11060 Fontaine Blvd – Grand Mtn School
PPR Amendment

PPR Amendment Comment Responses

**RE: Site Development Plan Civil Comment Response
PPR2611, 11060 Fontaine Boulevard
Grand Mountain PK-8 School
(Parcel/Tax Schedule # 55133-01-002)**

SHEET NAME
 SITE PLAN

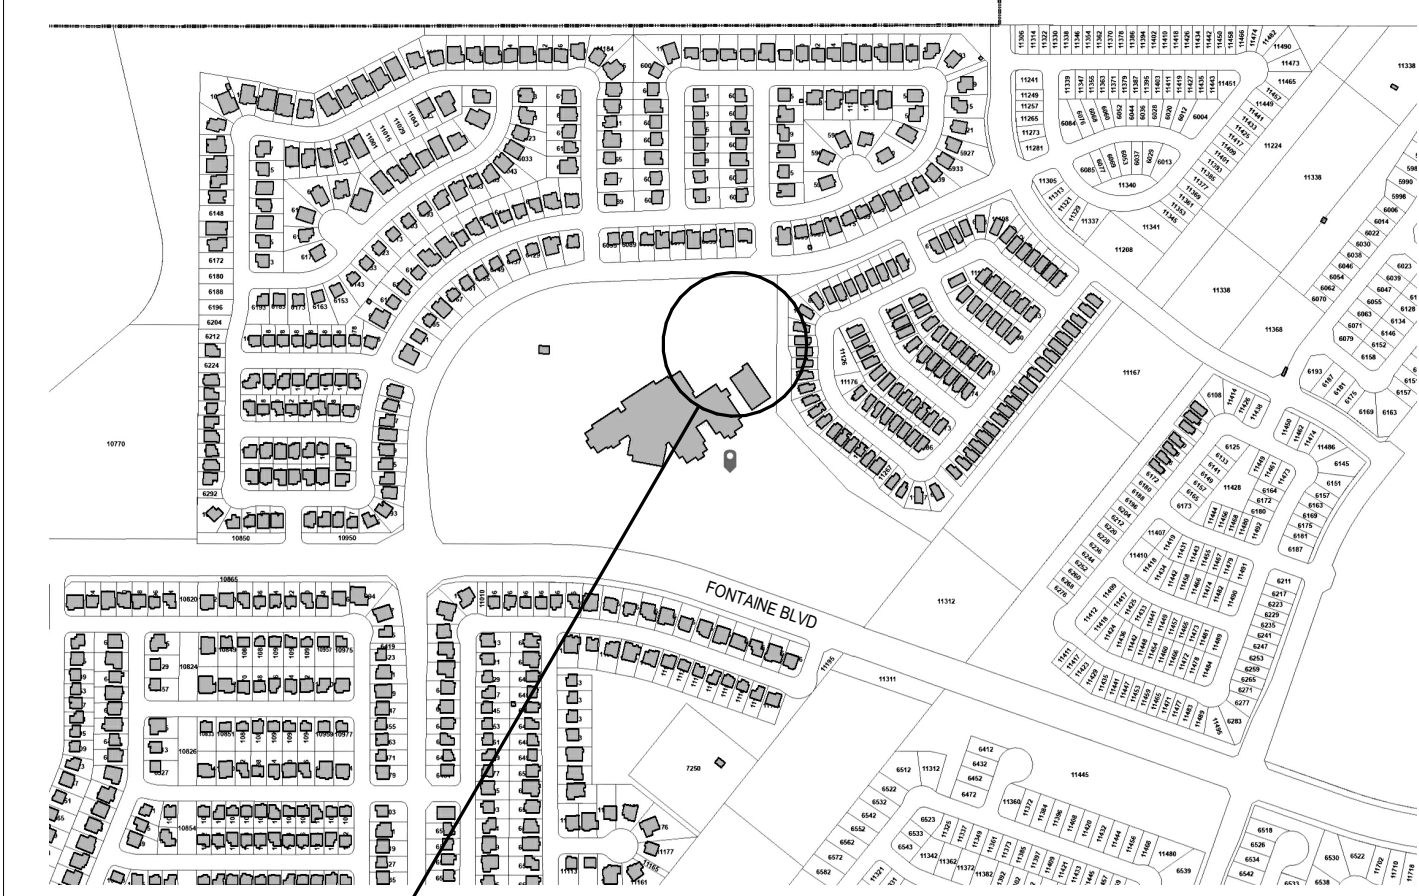
Include all existing easements in the subject area – please reference Plat No. 14288 for Lorson Ranch East Filing No. 1

Response: Addressed; existing easements added to plans.

A1.1

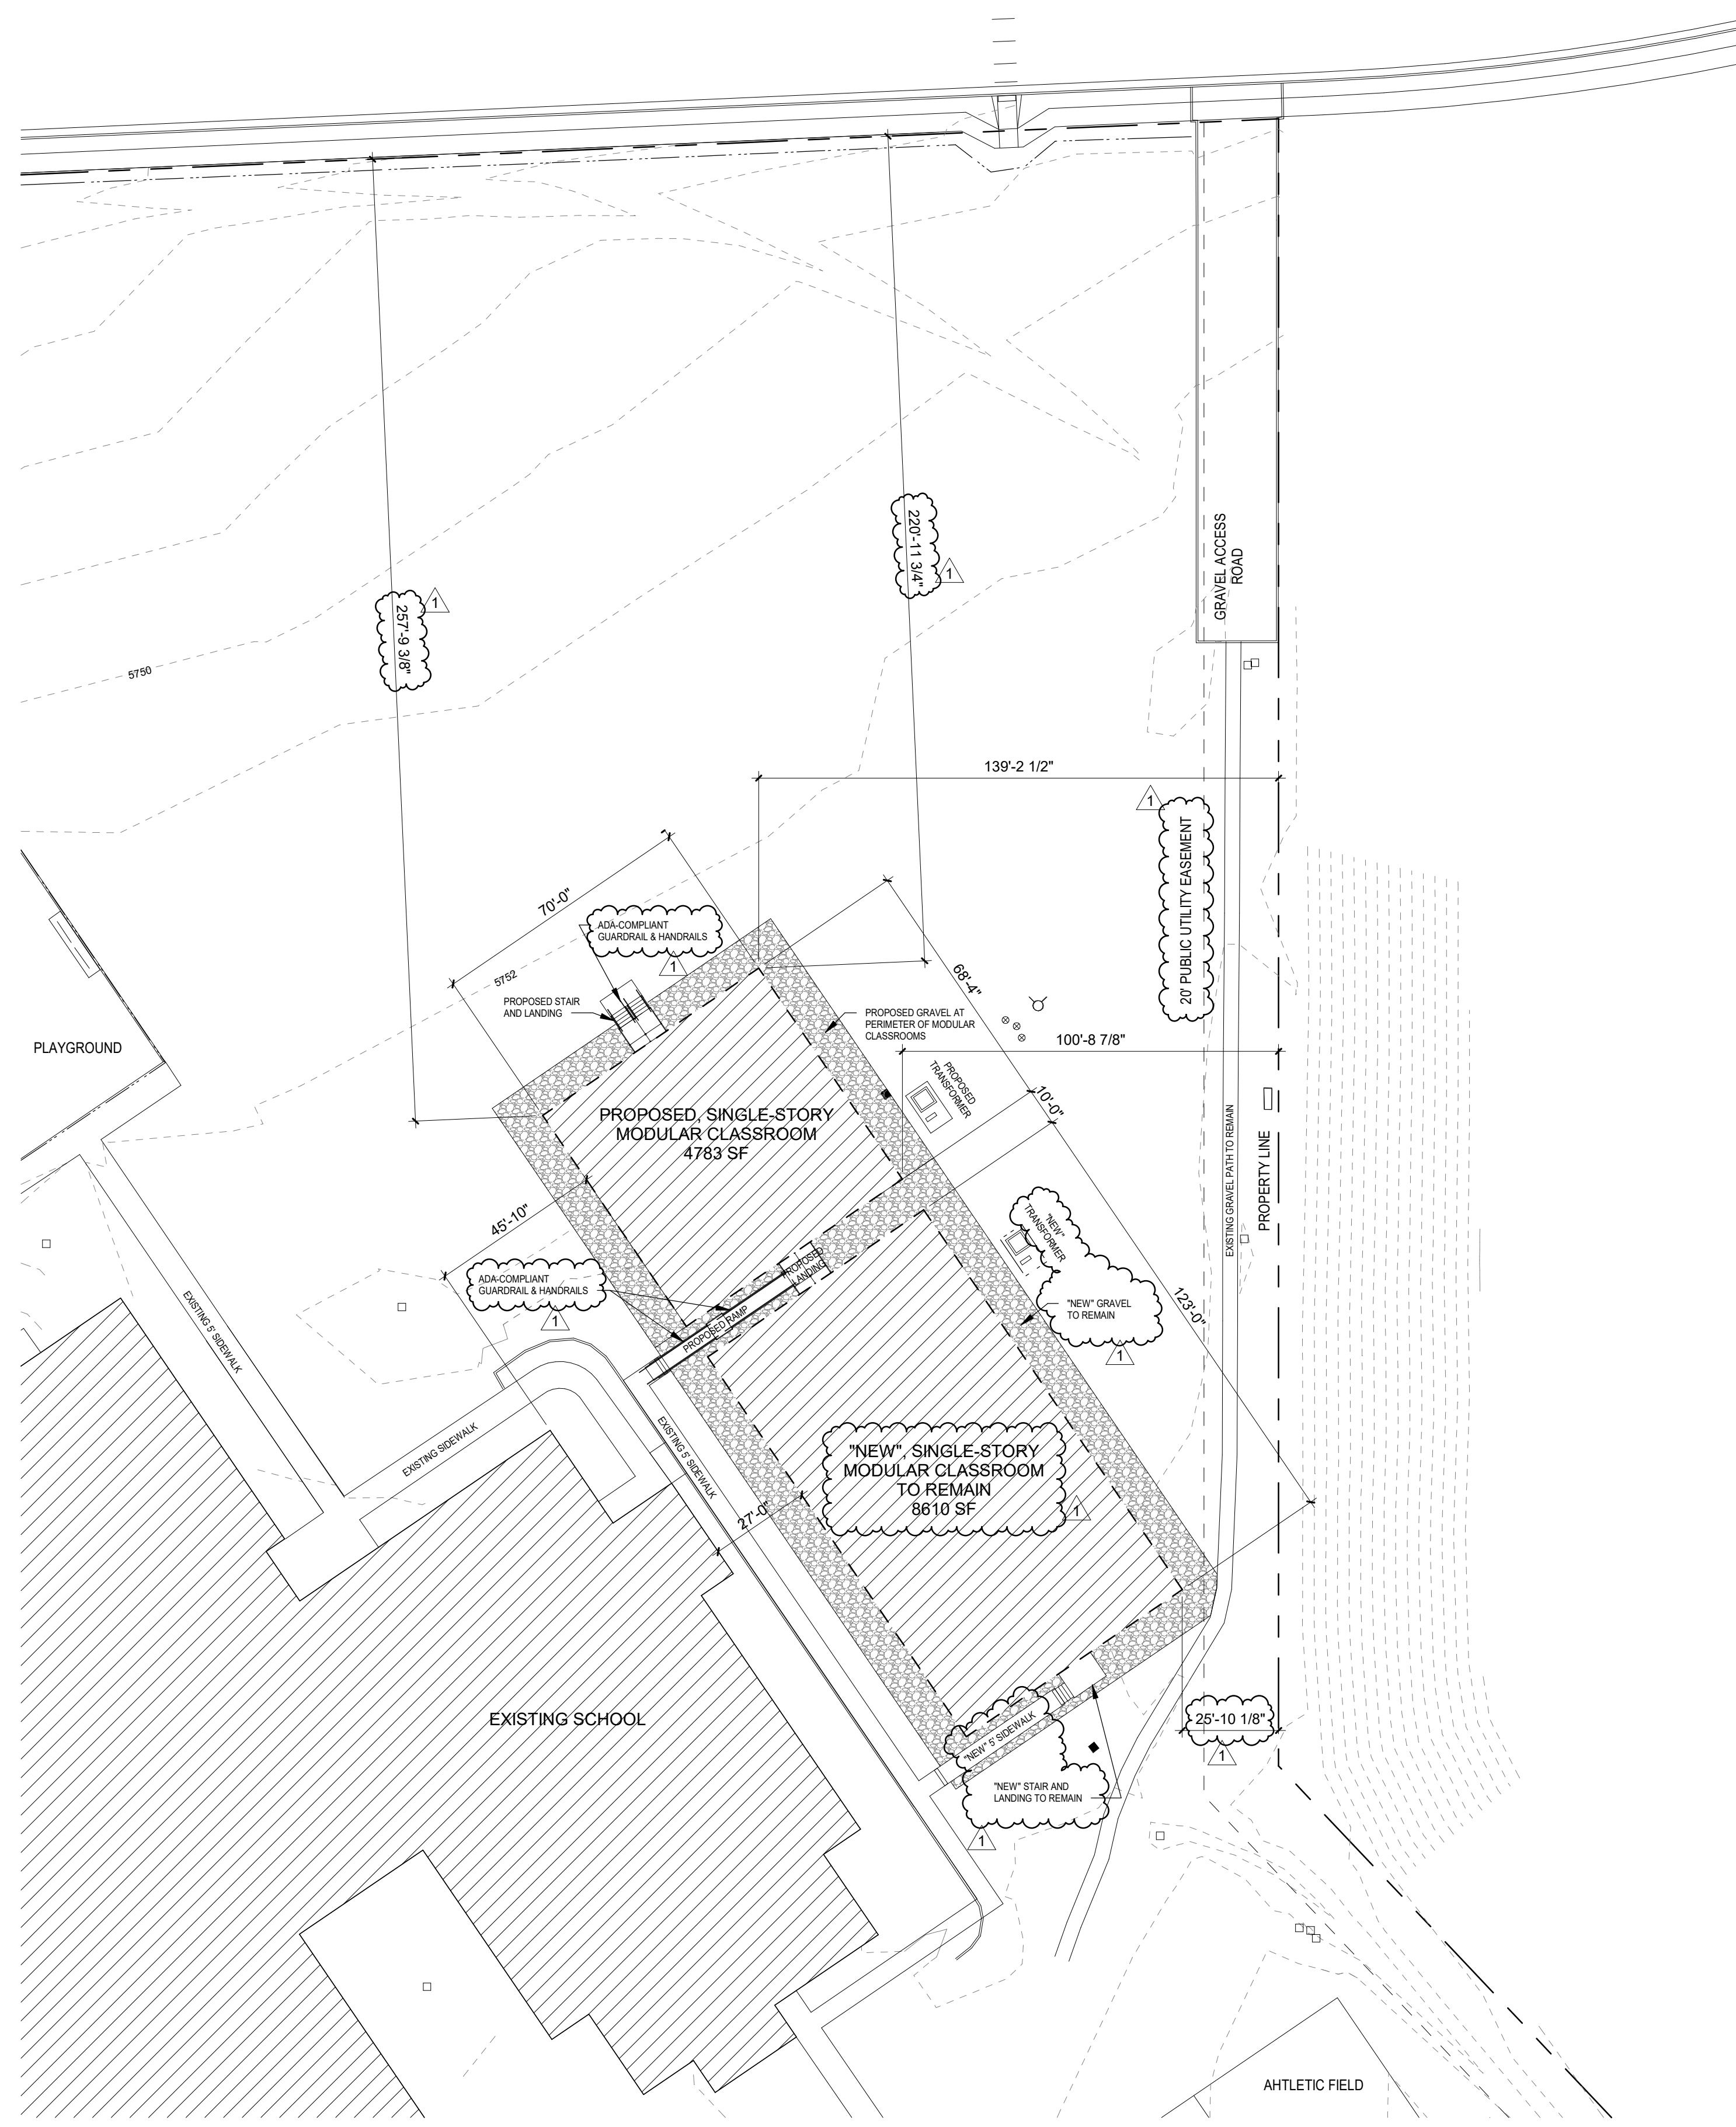
Label existing pond.

Provide legend for different linetypes & hatches.

Does new ramps have railing? If so, please label.

Ensure linetypes for different things look different and existing vs. proposed is clearly shown.

Provide dimensions to north property line from building corners, same as was done to east property line.

Please identify this structure as “PROPOSED” or “NEW”. This was added after approval of PPR1826, and was not included on any subsequent site plan amendments. Please address in all areas of this proposal, as necessary.

Response: Addressed; label added.

Response: Addressed; legend added.

Response: Addressed; note for railing added.

Response: Addressed; line styles revised to differentiate types. Proposed and existing elements labeled.

Response: Addressed; dimensions to north property line added.

Response: Addressed; to differentiate between the two buildings, the proposed 4783 SF classroom and associated elements are labeled “PROPOSED”, and the existing 8610 SF classroom and associated elements are labeled “NEW”.
